Appeal NO: PL 302 770

*Third Party Submission to Referral –
ABP-302770-18
(PA Reg Ref: P/DC/3/15/18)*

“Whether the conversion of a ground floor office space and seminar room to a one-bedroom studio apartment is or is not development or is or is not exempted development”.

*Ti Choinn, Gleann na Ri, Murrough, Galway
City*

01 Ground Floor Plan
 Scale: 1:100
 Unit Building area 750.88sqm
 Proposed volume area: 104 sqm

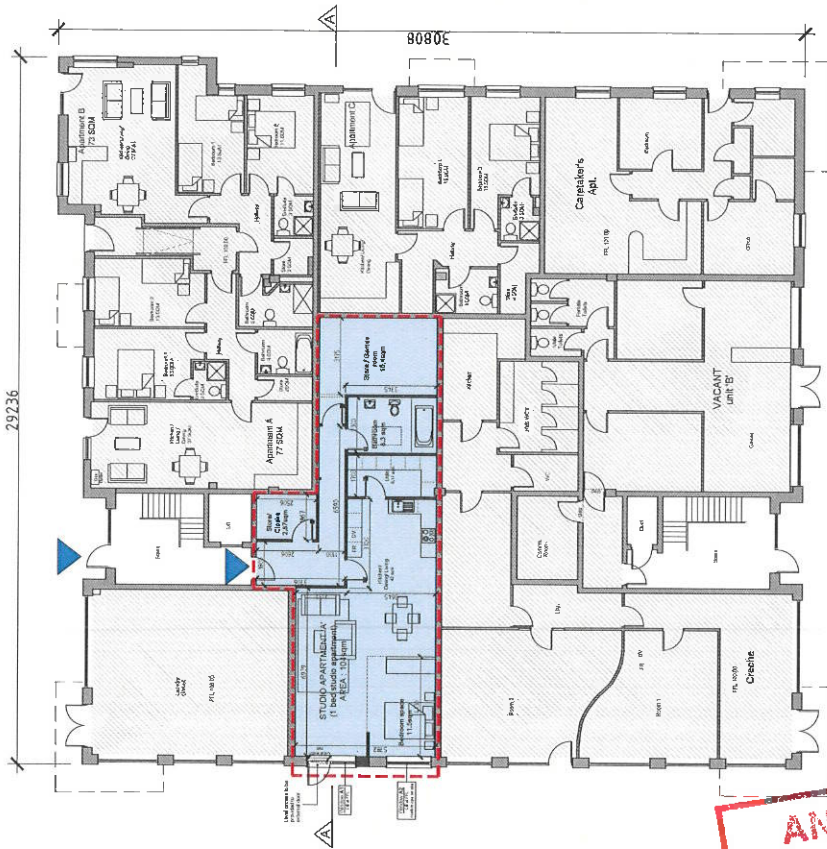
6(c)(iii) <i>"the structure concerned, or so much of it that is the subject of the proposed development, has been vacant for a period of 2 years or more immediately prior to the commencement of the proposed development"</i>	My clients wish to dispute the applicants assertion that the "Stairs Store" room was vacant 2 years prior to the commencement of development. We have been informed that this area had a tenant in situ as recent as July 2018. In this regard we refer to the accompanying letter from "Ocean Property Management." This letter outlines that this unit continues to function as a common services area. The applicants proposal seeks to supplant the existing Common area with a private "Store/Cloaks Room" to serve the subject studio apartment. Owing to the fact that this Room serves a communal function for

the overall Residential complex, it cannot be readily be relocated. ¹ As such, it follows that the proposed Section 5 conversion cannot be availed of. In the interest of due diligence, we request that as part of the Inspectors site visit, the location and content of the Comms room is inspected.
6(d)(i) <i>"The development is commenced and completed during the relevant period."</i>	This is subject to compliance with the other criteria.
6(d)(ii) <i>"Subject to sub-paragraph (iii), any related works, including works as may be required to comply with sub-paragraph (vii), shall affect only the interior of the structure and shall not materially affect the external appearance of the structure so as to render its appearance inconsistent with the character of the structure or of neighbouring structures."</i>	The applicant has not proposed to amend the external appearance of the structure to facilitate the proposed conversion.

6(d)(v) <i>"No development shall consist of or comprise the carrying out of works which exceeds the provision of more than 9 residential units in any structure."</i>	We understand this criteria was designed to ensure that Part V requirements (Social Housing), are not avoided. At present (as indicated on the drawings accompanying Pl. Ref. No. 15/359), there are 17 no. units within the structure. The proposed development could facilitate a total of 18 units. Furthermore, we refer to the parallel Referral (ABP-302769-18), which would facilitate the provision of 19 residential units within the structure. As the proposal would facilitate additional residential development in excess of the 9 unit threshold, the proposed development cannot be considered exempted, and would also circumvent Part V requirements.
6(d)(vi) <i>"Dwelling floor areas and storage spaces shall comply with the minimum floor area requirements and minimum storage space requirements of the "Sustainable Urban Housing: Design Standards for New Apartments — Guidelines for Planning Authorities" issued under section 28 of the Act or any subsequent updated or replacement guidelines."</i>	At face value, the proposed drawings would appear to comply with the latter criteria. However, owing to the continued function of the common services within the "Stairs Store" room, and the inability to relocate the inherent trip switches, switchgear and water stop valves in this area, the proposed private "Store/Cloaks Room" cannot be provided as part of the proposed studio apartment. In these circumstances, the proposal cannot be considered exempted development.

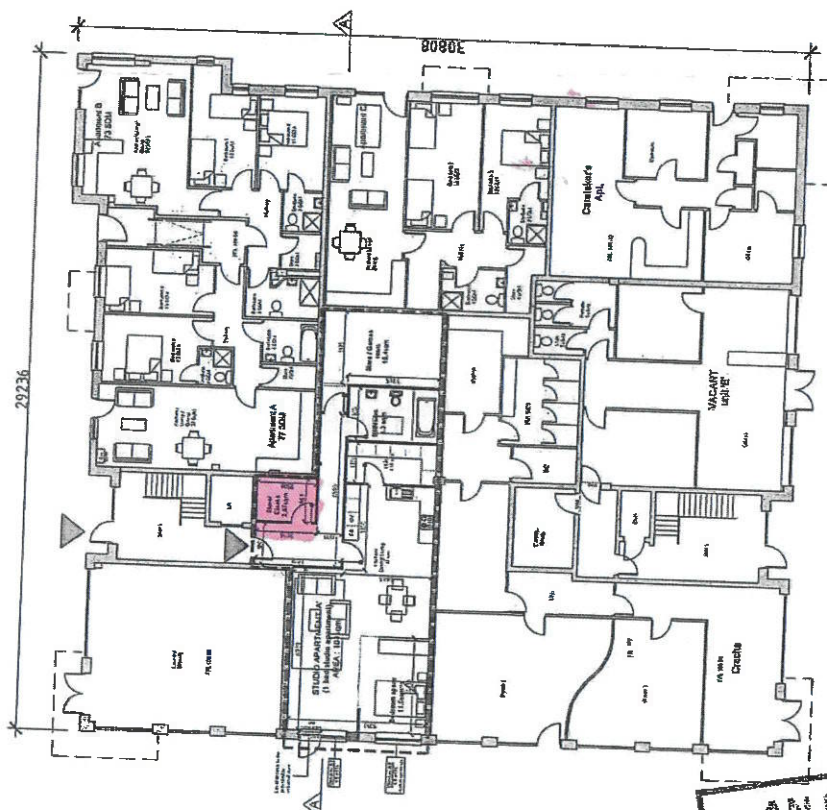
In addition, the proposed drawings ignore the existence of essential common area services including the trip switches and switchgear of the building and the water stop valves of seven apartments located on the first and second floors on the premises. I have outlined the location of these services on the attached drawing. It is vital that the management company maintains access to these essential services.
